Re: PA22-042 – Sunnyside Village Co-Housing – Technical Review 2
3121 66th Ave NE – APN: 29050300402100

After preliminary review of the above referenced proposal, the Planning Division has the following comment(s):

RE: Sunnyside Village Co-Housing, File# PA22-042
32 – lot cottage housing development
3121 66th Ae NE & Parcel # 29050300402100

A000

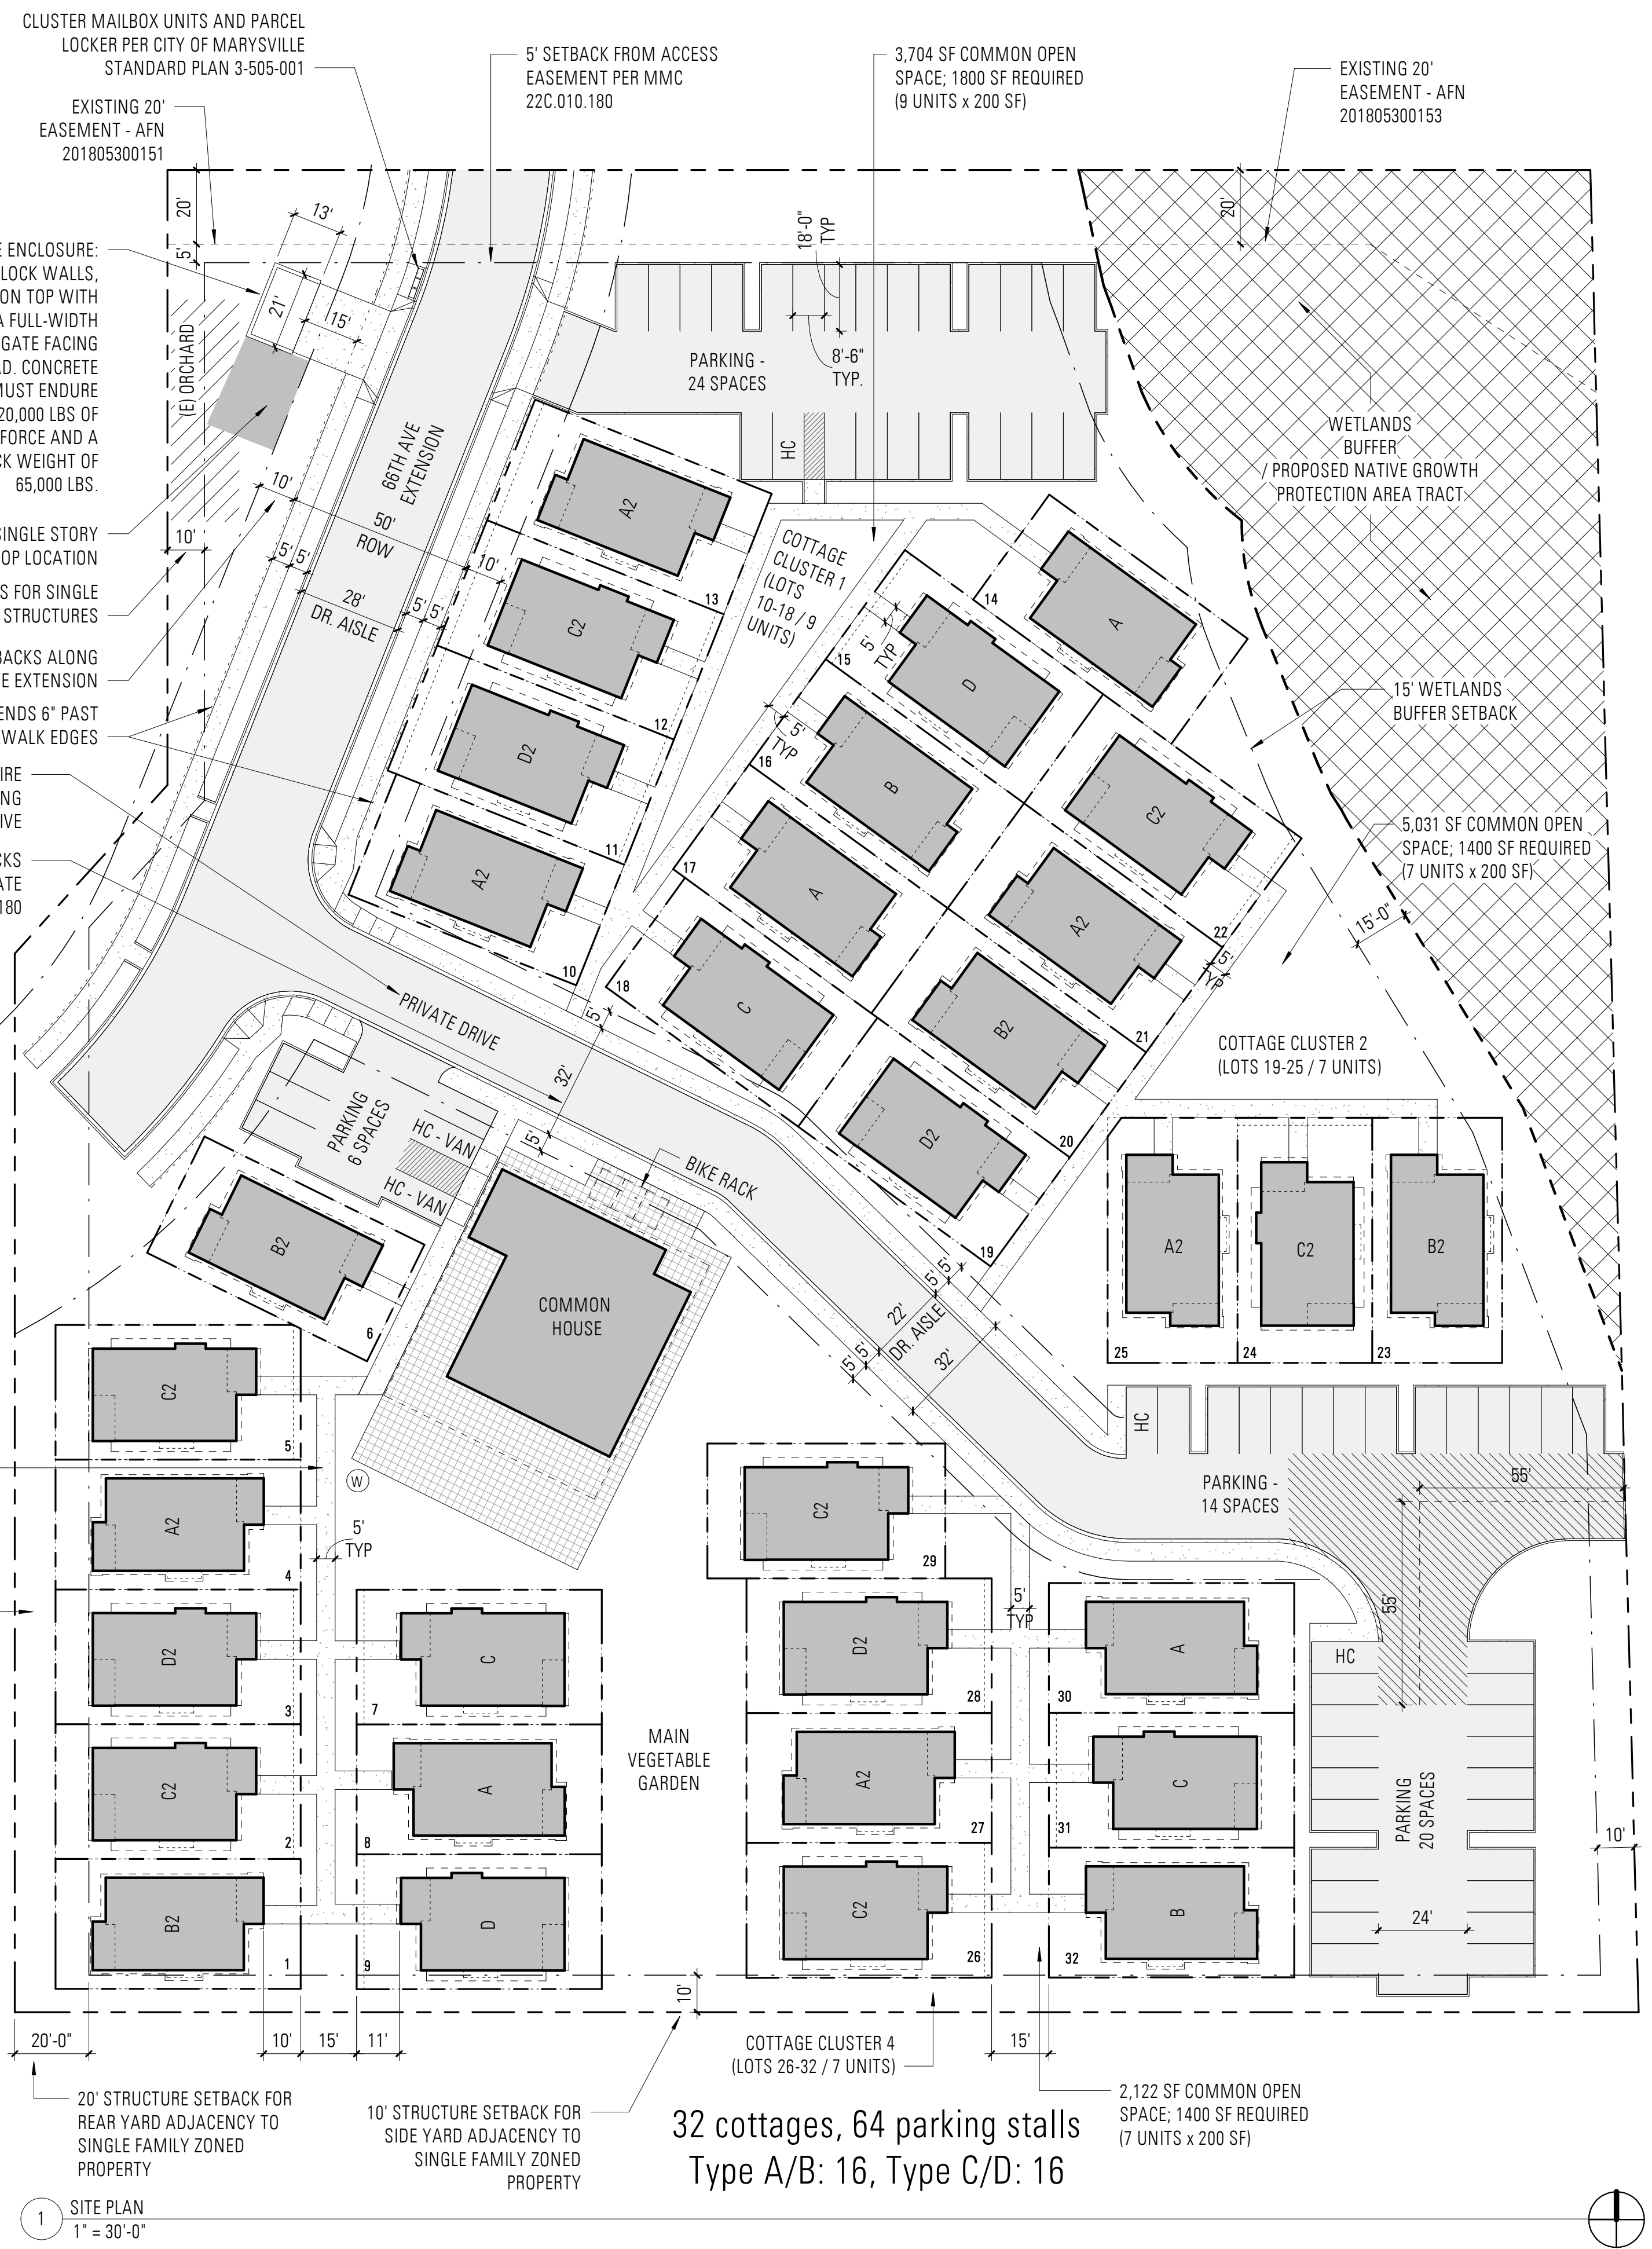
1. Revise the NPGA tract to be delineated via solid lines (rather than dashed) as this area would be a completely separate tract/lot. Clearly label accordingly NPGA tract accordingly.
